AMENDMENT RECORD SHEET - LIVE APPLICATION

PLANNING AMENDMENT

H16/0143/01

27 Mallard Road, Low Fulney, Spalding.

BLOCK PLAN 1:500

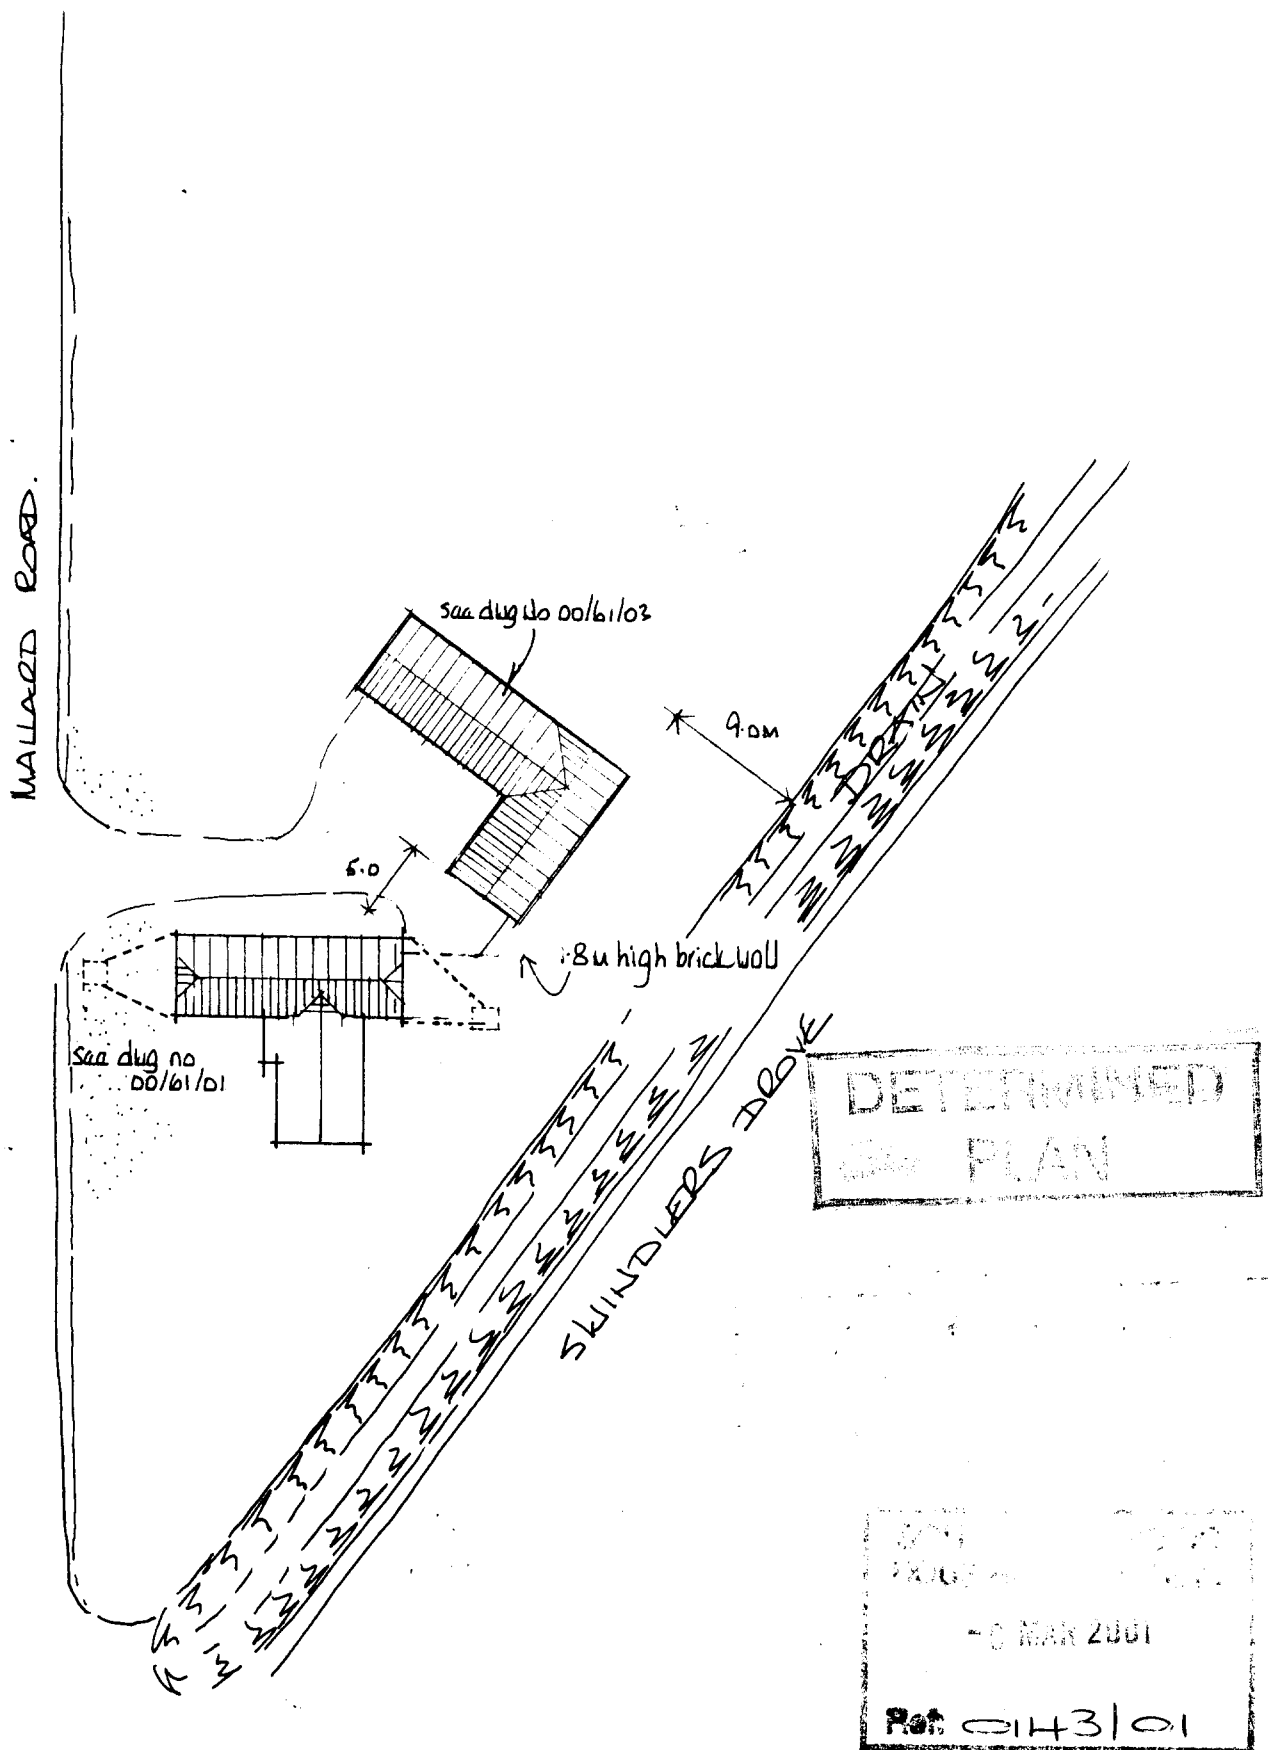
- The site is adjacent to my Board's Old Exeter Drain and it is noted that the proposal will contravene my Board's Byelaws which apply to the channel.
- May I respectfully bring to your attention that the Byelaws, enforceable by the Land Drainage Act 1991, prohibit any works (including tree planting) in, over under or within 9 metres of a Board's watercourse without the prior written consent of the Board, **irrespective of any planning permission granted.**

I will be pleased to learn that the proposals will be amended to comply with the Byelaws.

Thank you for your letter and revised plan relating to the above project which I can confirm indicates compliance with my Board's Byelaw limit applying to Old Exeter Drain.

Drawing Title: Plan & Elevations

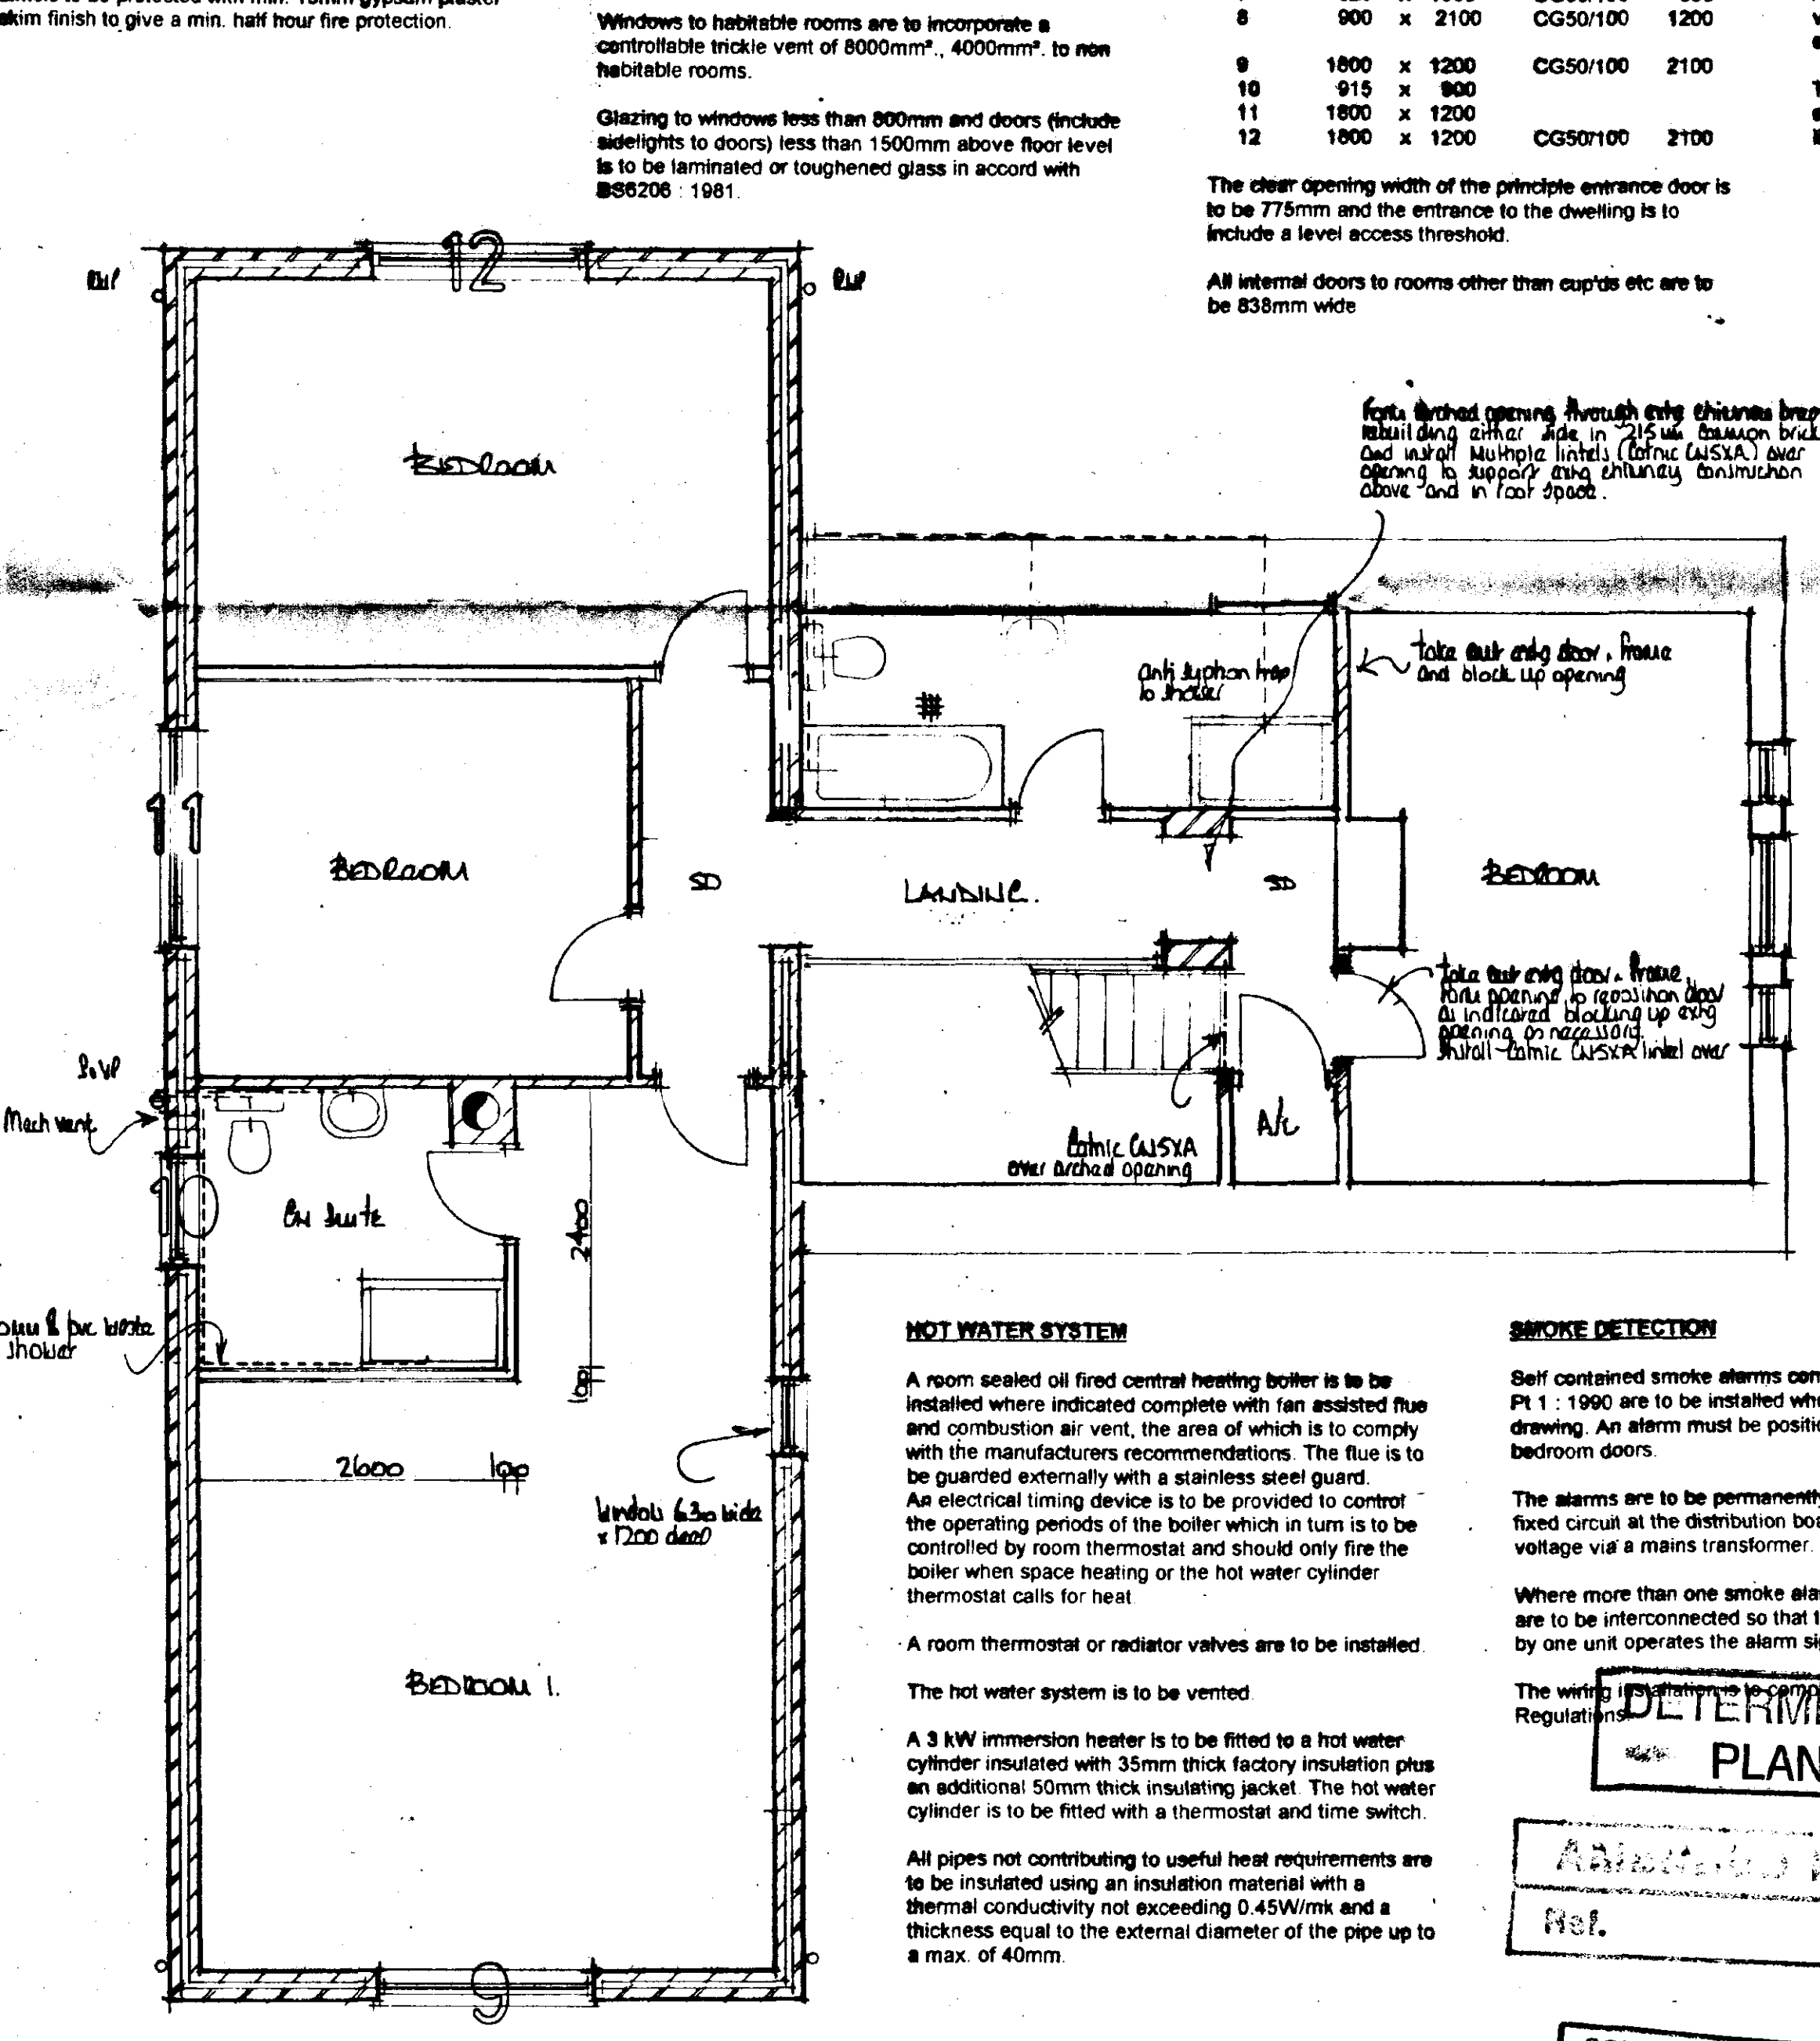
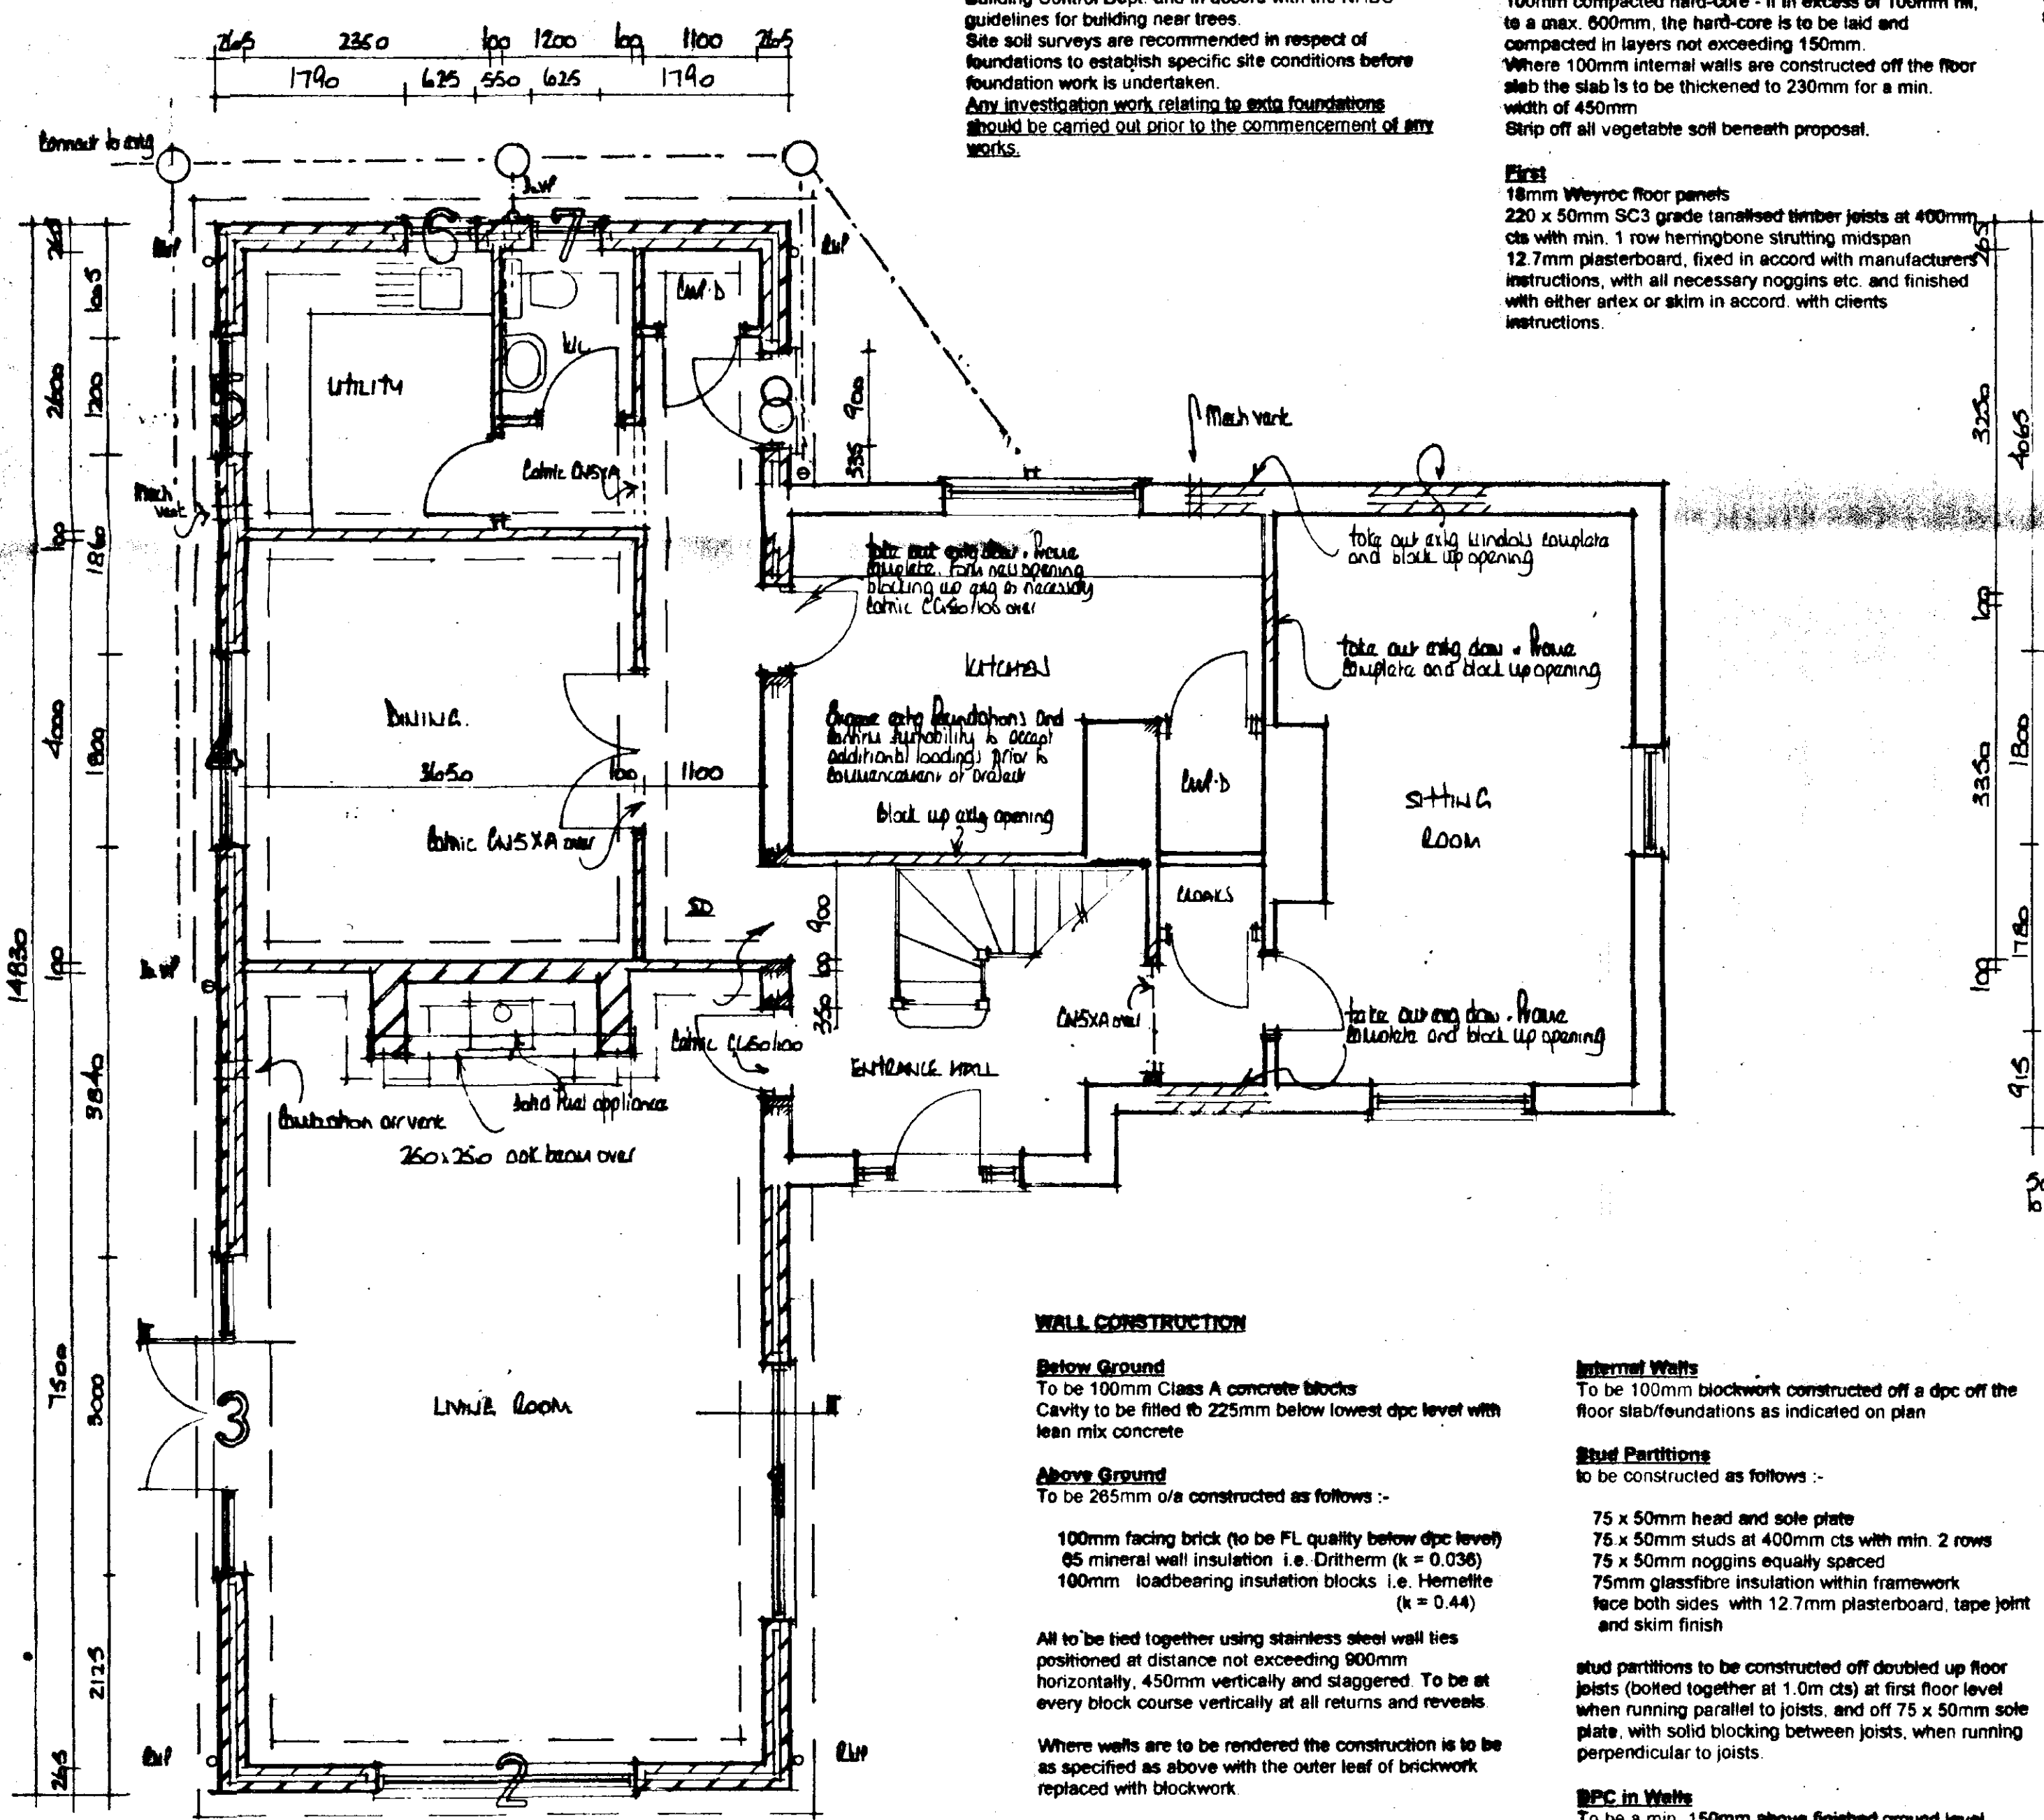
The size of the proposed extension to the existing dwelling house concerns me, especially in relation to it's height, since it will dominate the existing dwelling. I therefore write to ask whether the extension can be reduced in height so that it does not dominate the existing building as much.

ROOF STYLE AMENDED TO REDUCE RIDGE
HEIGHT OF MAIN EXTENSION TO DWELLING
